# CITY OF ALBUQUERQUE

December 17, 2015

**RE: Westgate Heights Park Addition, Unit 2 (File: M09D008B)**  
**8810 Sonya Ave. SW**  
**Grading Plan and Drainage Plan**  
**Engineer's Stamp Date – 12/010/2015**

Based upon the information provided in your submittal received 12-10-15, the above referenced Grading Plan and Drainage Plan cannot be approved for Grading Permit and Paving Permit until the following comments are addressed.

WESTGATE HEIGHTS PARK
DRAINAGE AND GRADING PLAN 2 OF 2

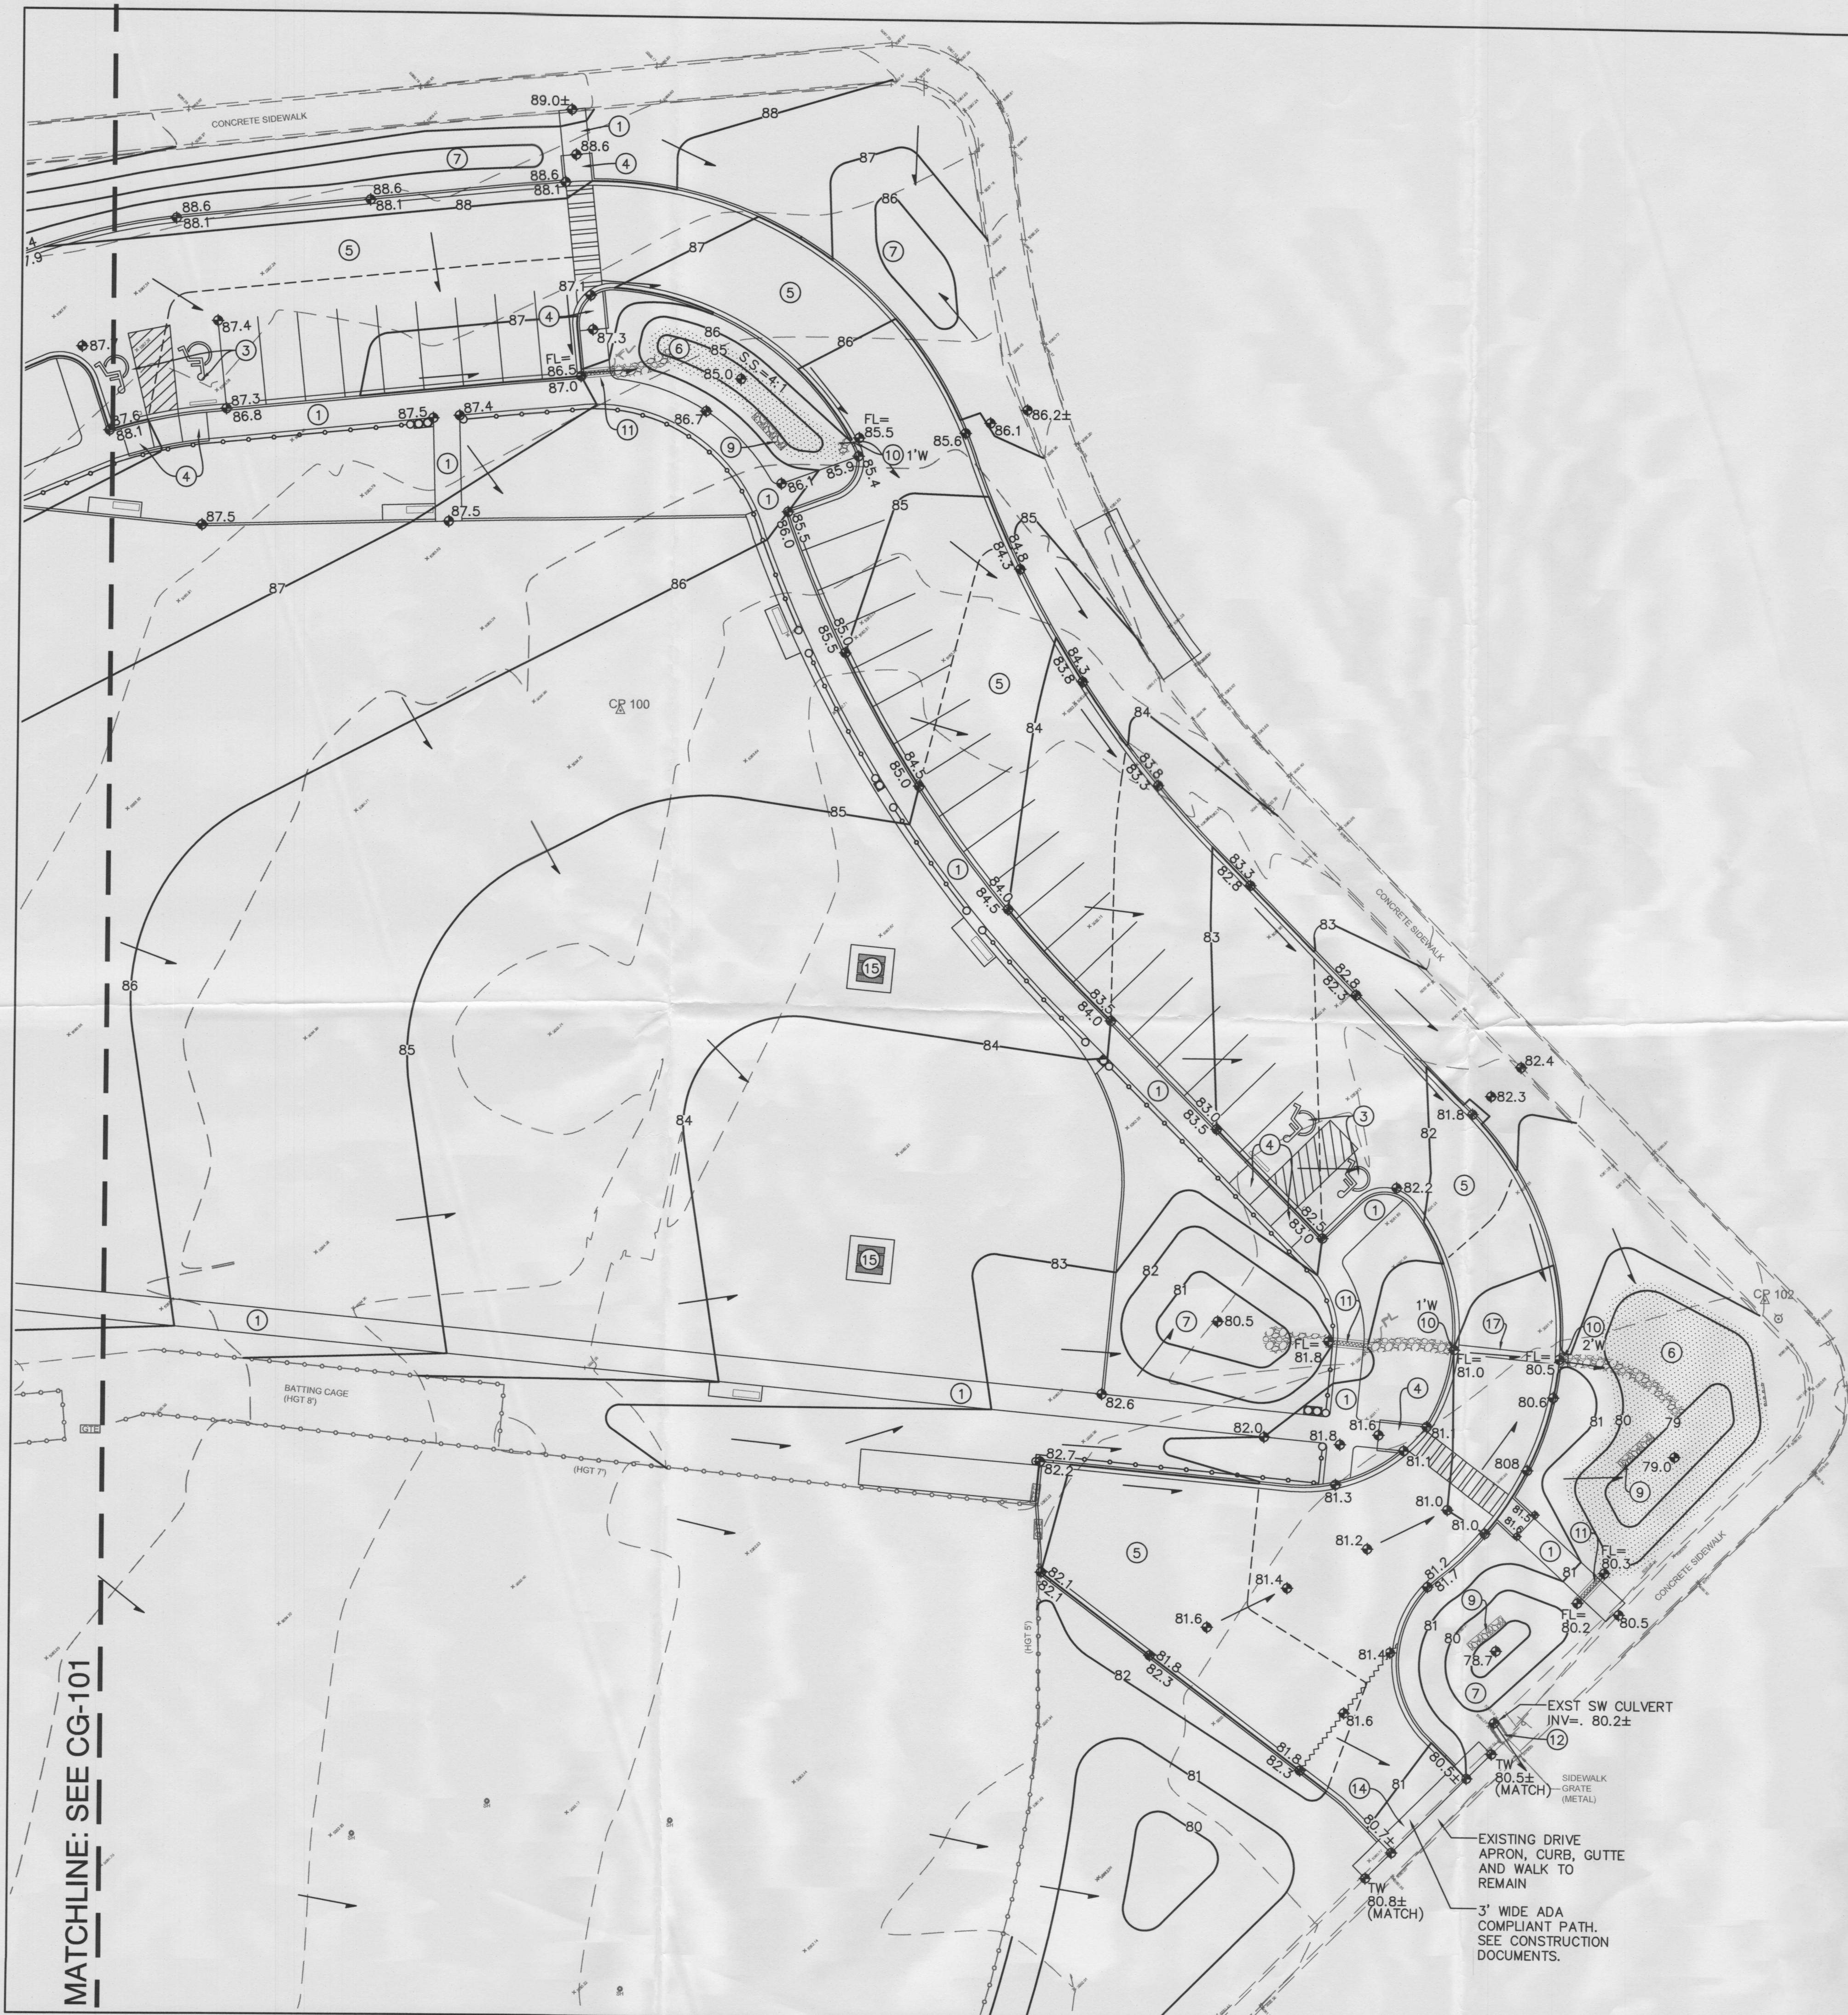
- Provide spot and contour elevations on the Overall Grading and Drainage Plan sheet.
- Provide flow line elevations at the outfall for each proposed sidewalk culvert onsite.
- The total area for historic flows does not match the total area for developed flows in the Calculation section of the Overall Grading and Drainage Plan sheet. Review this information to ensure the total basin area for existing and proposed conditions match.
- The area of land treatment D used in the First Flush calculation shown appears to be based on information provided in the previous submittal. Update the First Flush calculation on the Grading General Notes and Details sheet to reflect the changes to the area of land treatment D shown in the Calculation section of the Overall Grading and Drainage Plan sheet.
